**Rezoning Transportation Analysis**  
**Petition Number: Insert Zoning Petition #2021-047**  
*General Location Identifier: Tax ID 04924207*

**From: Robyn Byers, Ph.D.**  
Robyn.Byers@charlottenc.gov  
704-336-7404

**Reviewer: Walta Blackmon**  
Walta.Brumskine@charlottenc.gov  
704-432-1556

Date	Description
04.29.2021	First Review (WB)
05.27.2021	First Review (WB)

RZ-2

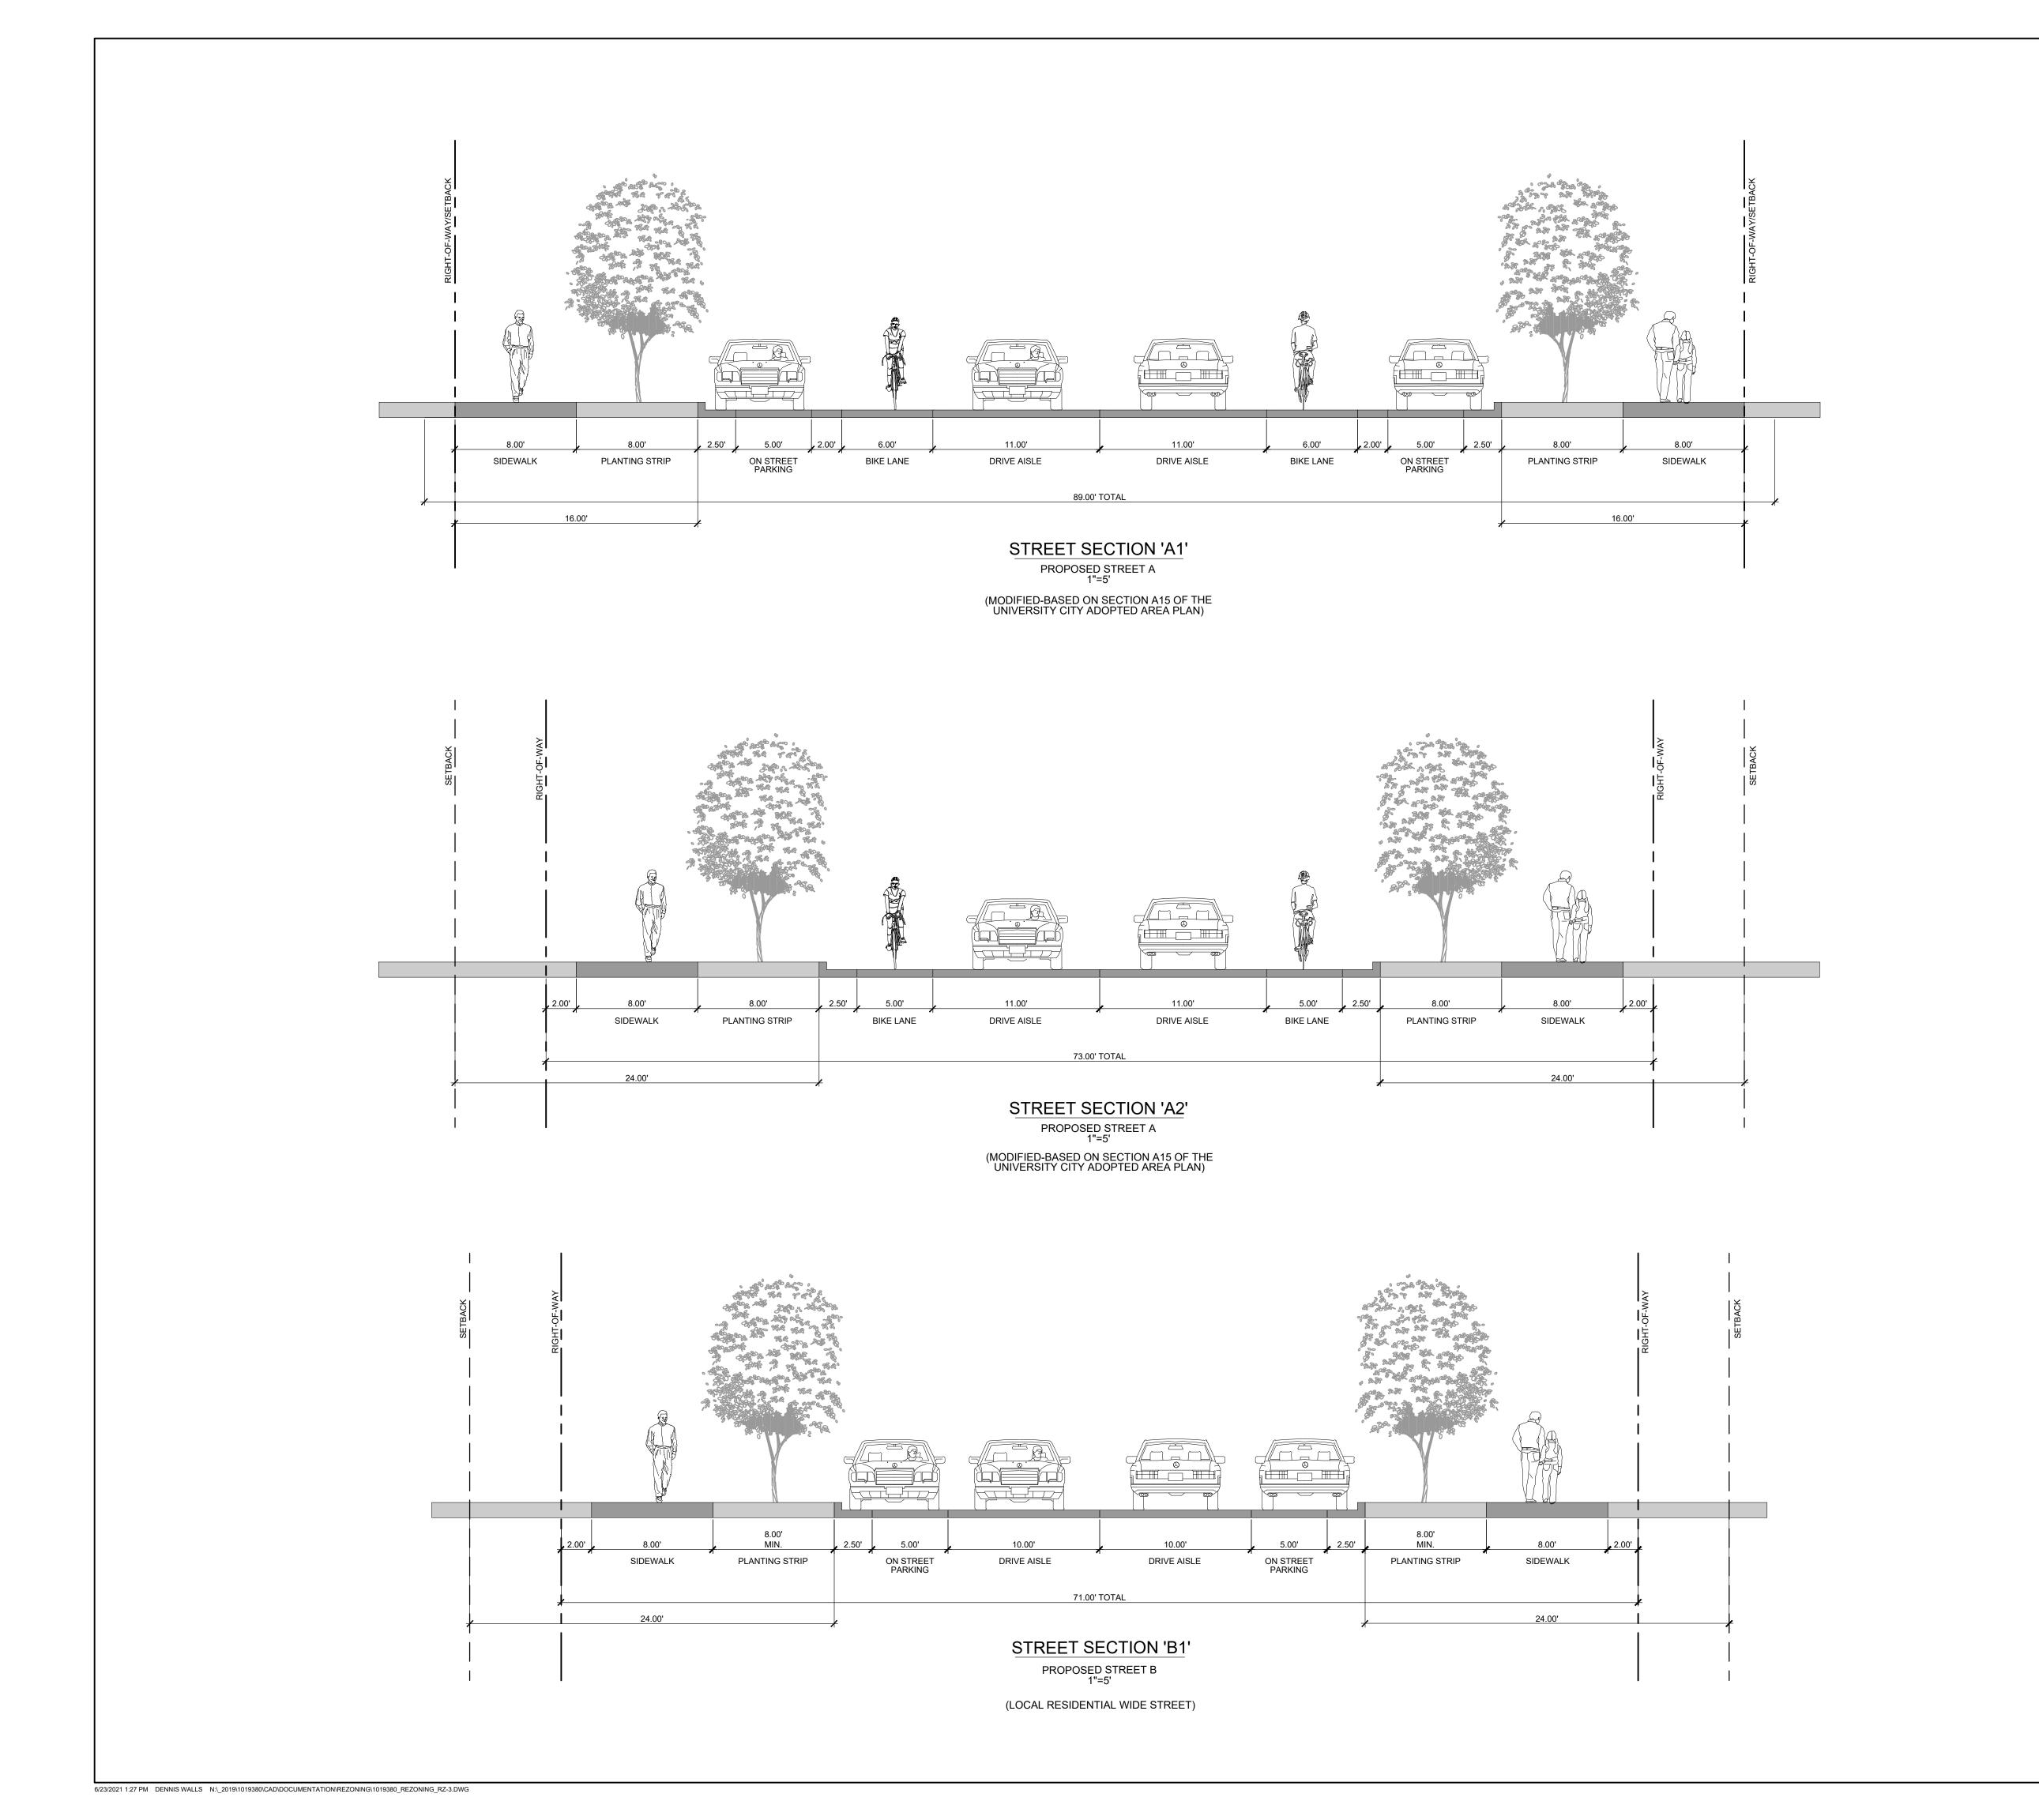
~~2. Please provide clarification on the two new site plan conditional notes listed under 3. Transportation Improvements and Access. | Proposed Improvements, c and d.~~
